Planning Officer: Miss Z Toppin
Planning Application Ref: AB/57/21/T
Location: Verge to South of 1 London Road, Arundel, BN18 9AZ
Description of works: Various works to 1no. holm oak tree
Reasons given: 1. Condition of tree 2. Nuisance
Comments on Application:

Holm oak / *Quercus ilex* Height: 15-20m Spread: 5-10m Age class: Late mature

Figure.2 Illustrates proposed limb cuts. From left to right, limbs of approx. Ø 5cm & 3cm to be cut.

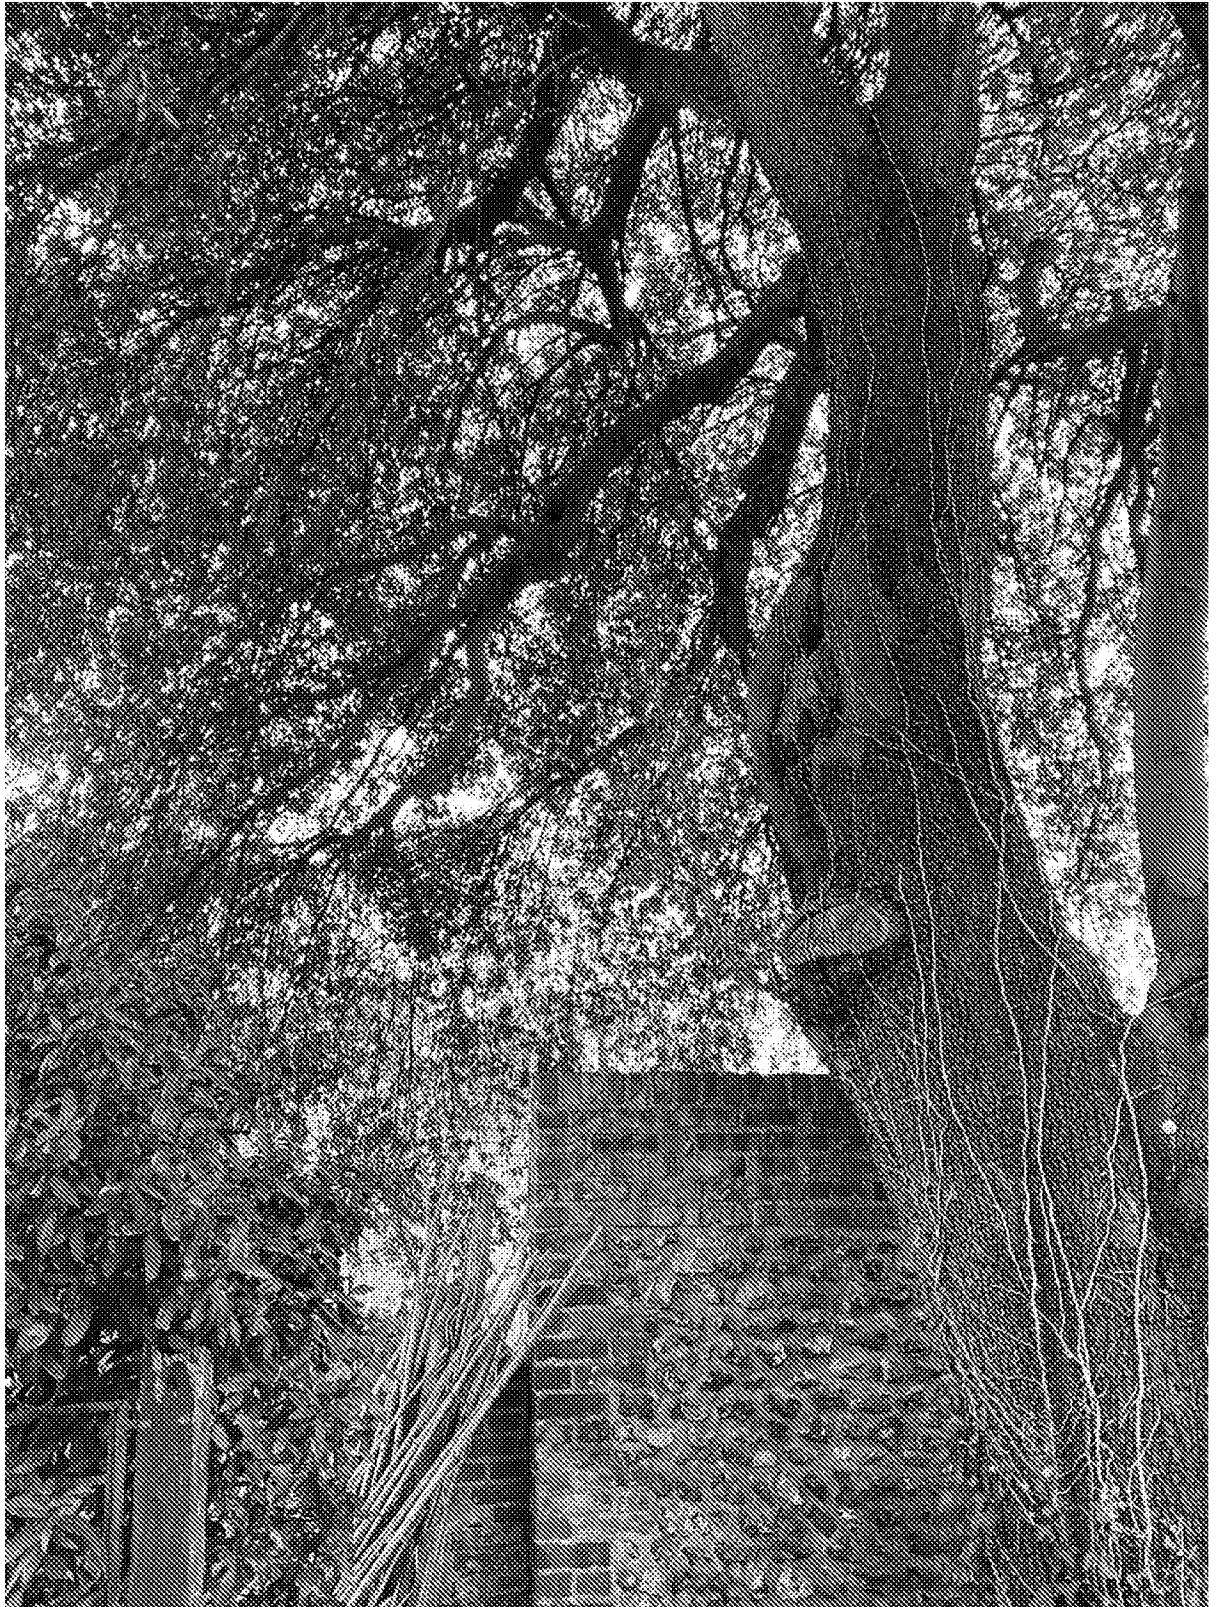
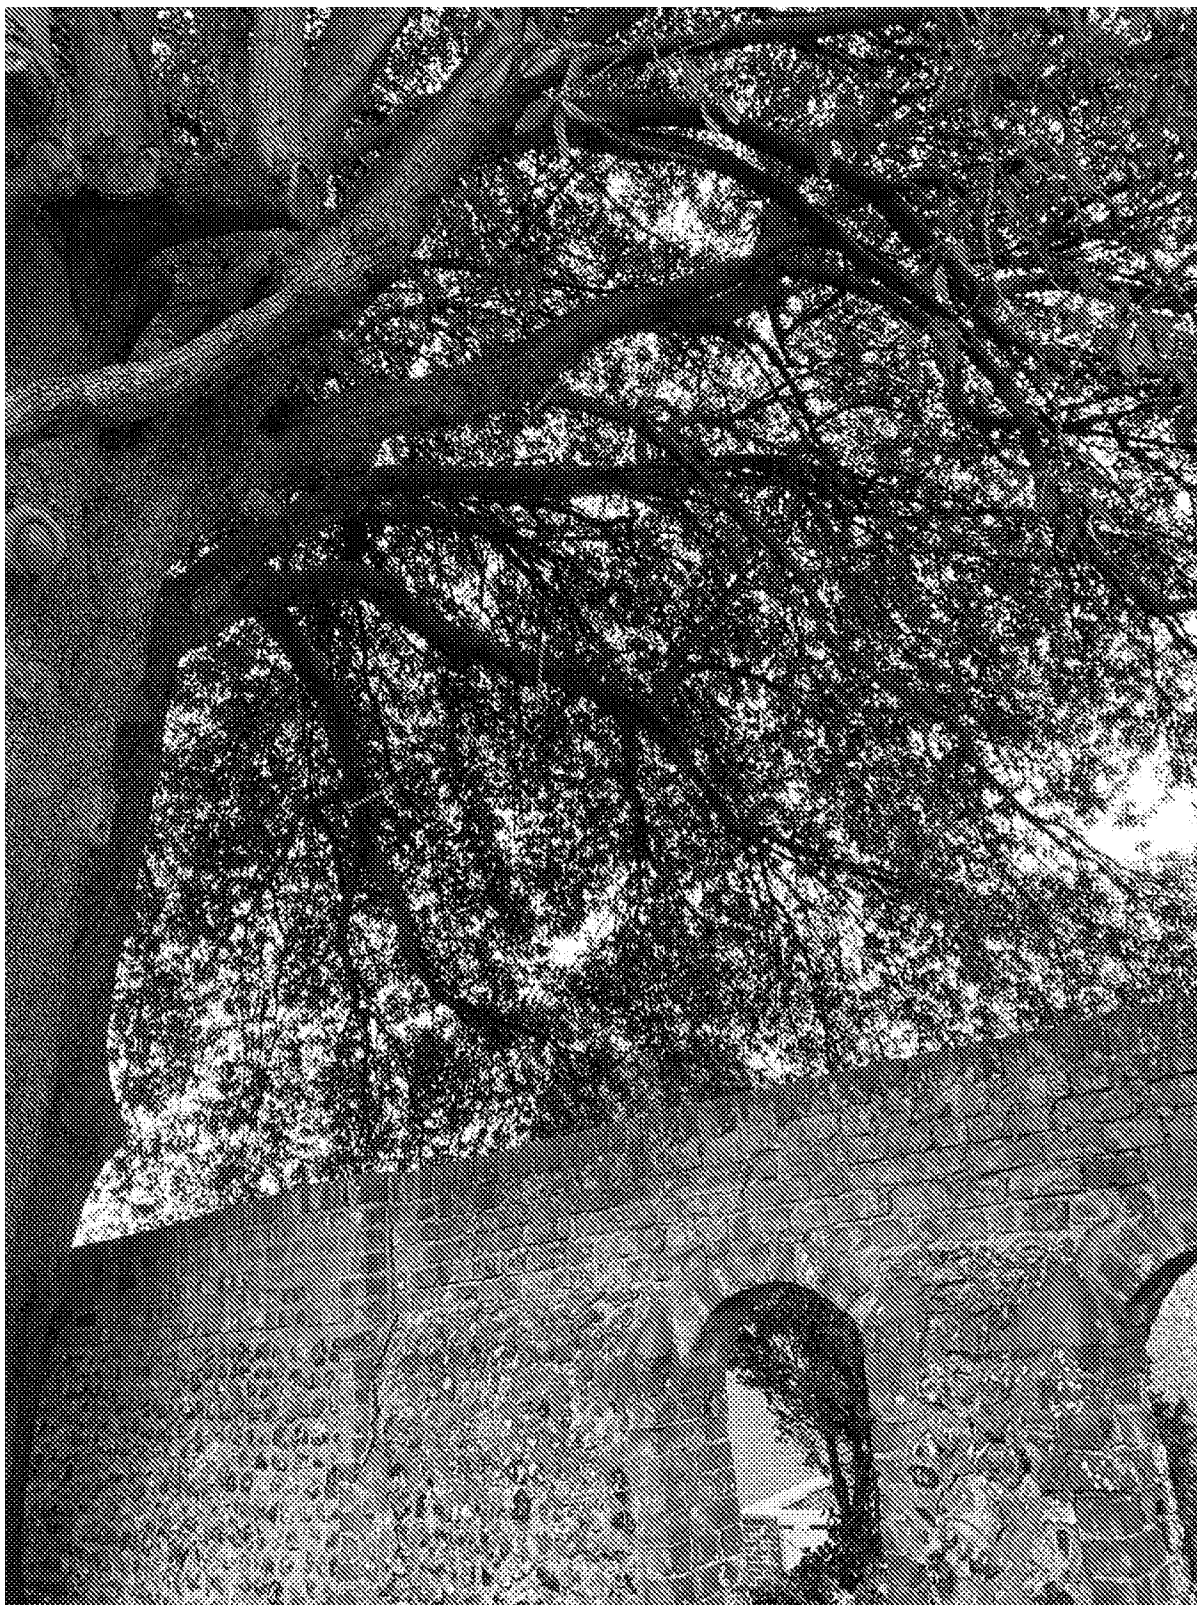
- The work proposed is justified on arboricultural grounds. This is a landmark tree of significant public and visual amenity which is to be carefully pruned to maintain reasonable enjoyment of residential property and with respect for natural tree form.
- If the work is undertaken to a high standard and at the right time; then the tree should be able to remain a long-term visually interesting feature in the local landscape.

- Part a) Where whole branches are to be removed and final cuts made close to the trunk or branch union they are to be made as shown in Figure 2 of BS3998:2010
- Part b) Where branches are to be shortened back the final cuts are to be made at the correct angle shown in BS3998:2010 and adjacent to a live bud or lateral.
- Part c) No final cut shall exceed the maximum permitted diameter of 75mm.
